Application No: A/184/21/PL
Site Address: Land South of Water Lane Angmering
Description of works: Construction of a weir upstream of the culverted road access to the Land South of Water Lane Development, Angmering as Phase 1 of the Angmering Flood Alleviation Scheme. This application is in CIL Zone 1 & is not CIL Liable as other development.

Thank you for your internet representation made on 11th November 2021 which has been recorded as support with the comments as follows:

TITLE: FLOOD ALLEVIATION SCHEME - WATER LANE
INDICATIVE FLOW CONTROL STRUCTURE
PLAN & SECTION

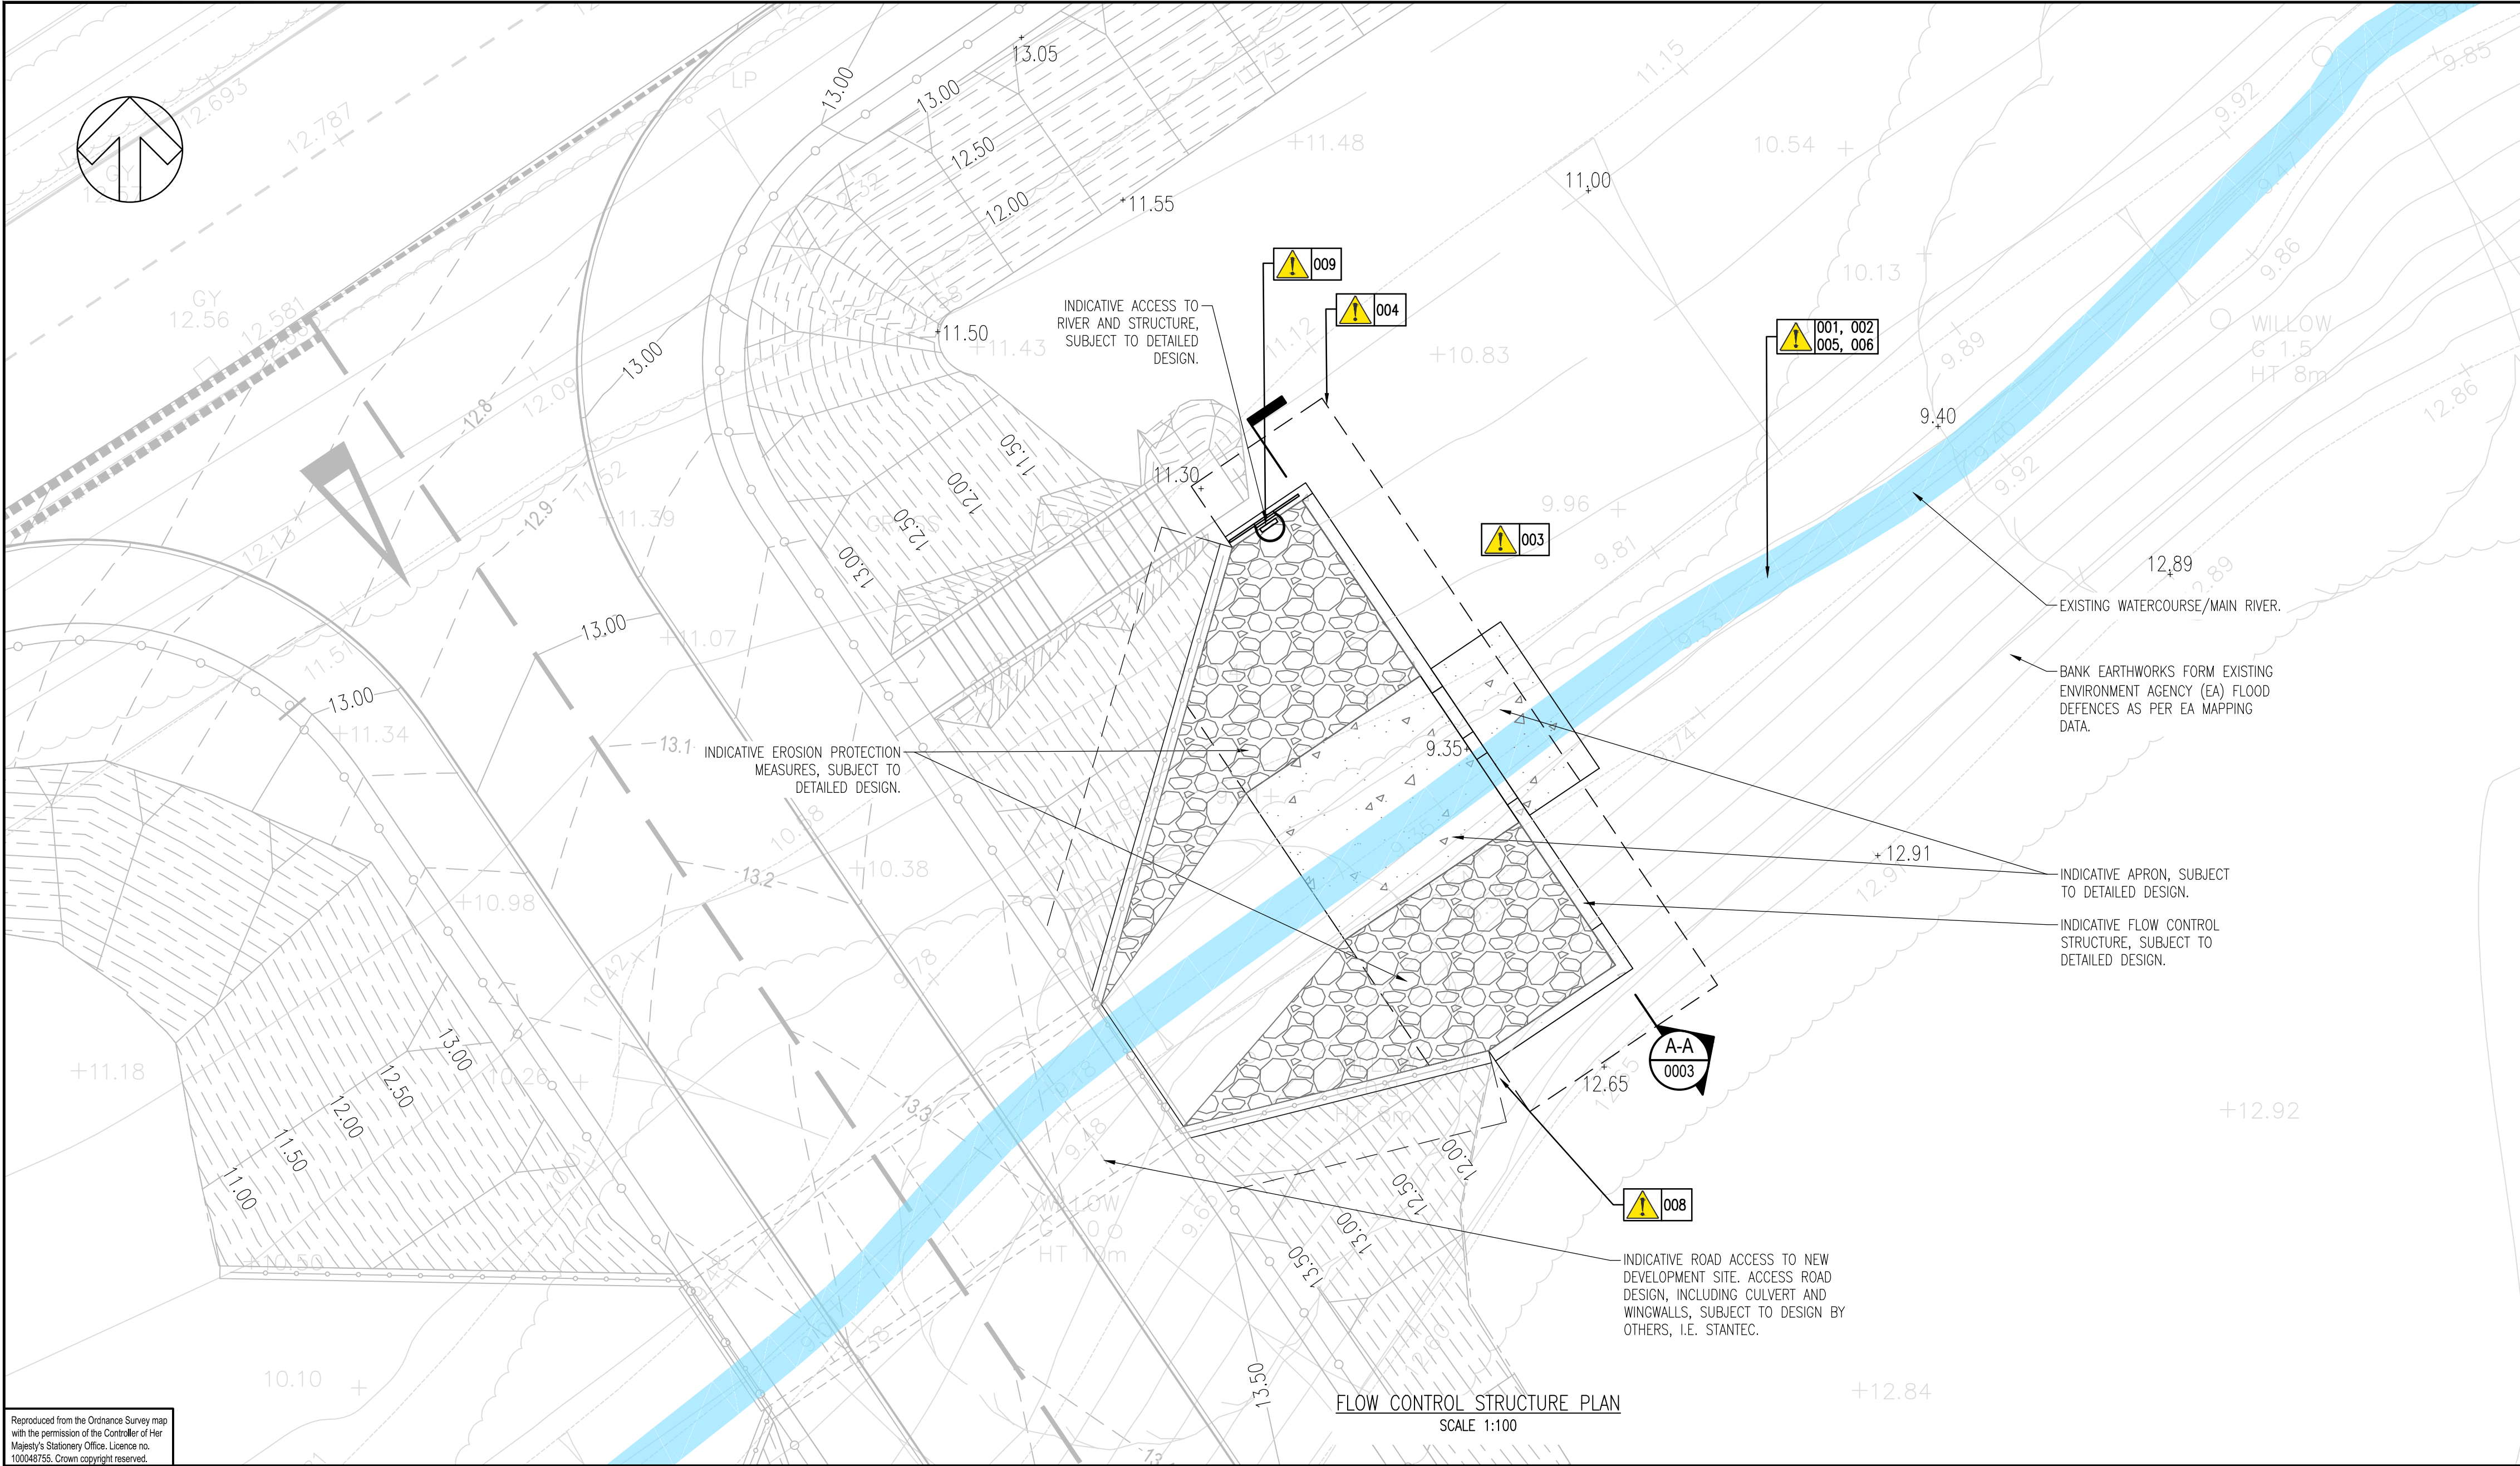
Bullet two. My examination of the drawings indicates that the invert of the orifices through the structure is the same as the existing river bed level. Thus I cannot see that the risk of silt accumulating upstream of the structure is any greater than for the existing Black Ditch. Thus, how silt will be removed, is irrelevant.

Bullet four. I don't understand 'perched flow' in this context. I, however, comment that I consider the half a kilometre of downstream highway culvert (with no light shafts) to be a significant impediment to eel passage already. I don't therefore see how this proposal with a similar bed level at the structure to the original channel increases this impediment.
